Development Control
Ribble Valley Borough Council

App no: 24.0325

Address: Primrose Mill Business Park Primrose Road Clitheroe

Proposal: Proposed access alterations involving removal of existing wall nibs to widen gateways to the existing site entrance to improve space for delivery vehicles. New metal security gates fitted to suit set into the site

Drawing Title
Proposed Site Plan and Sections

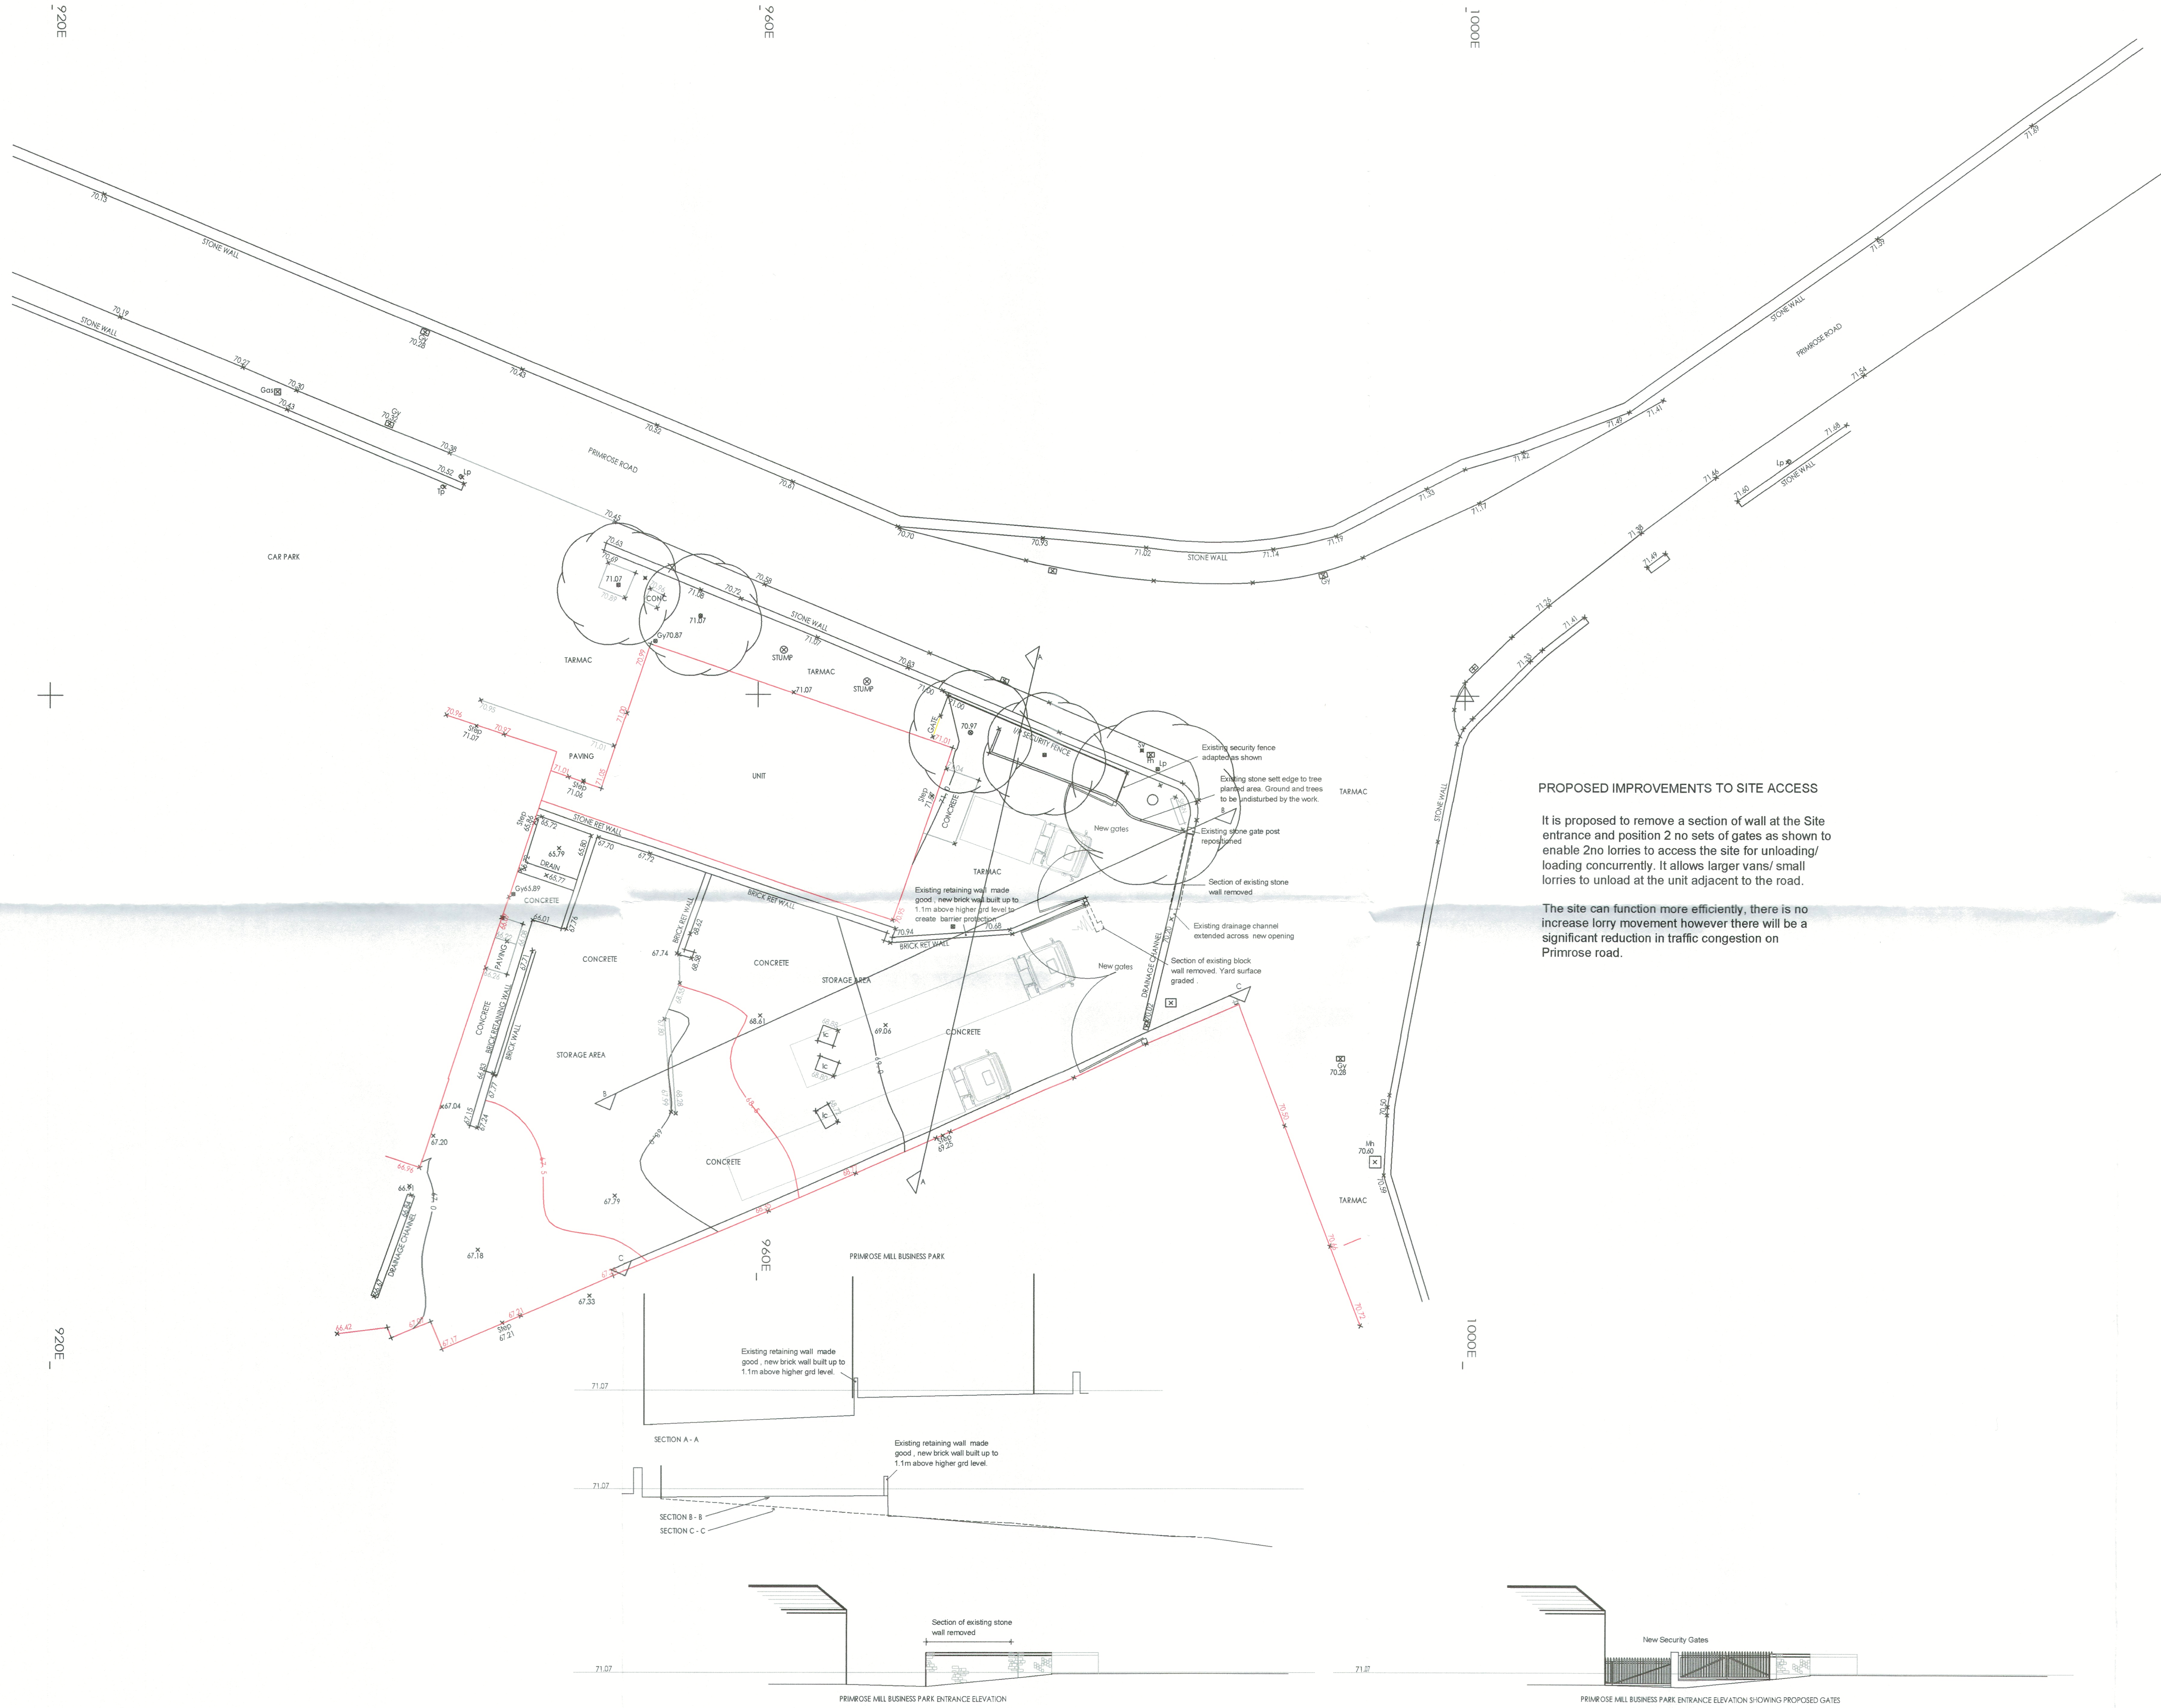
The proposed access alterations will improve the manoeuvring space for large vehicles which will reduce the impact of large vehicles waiting on the highway which is supported.

There are no alterations to the adopted highway.
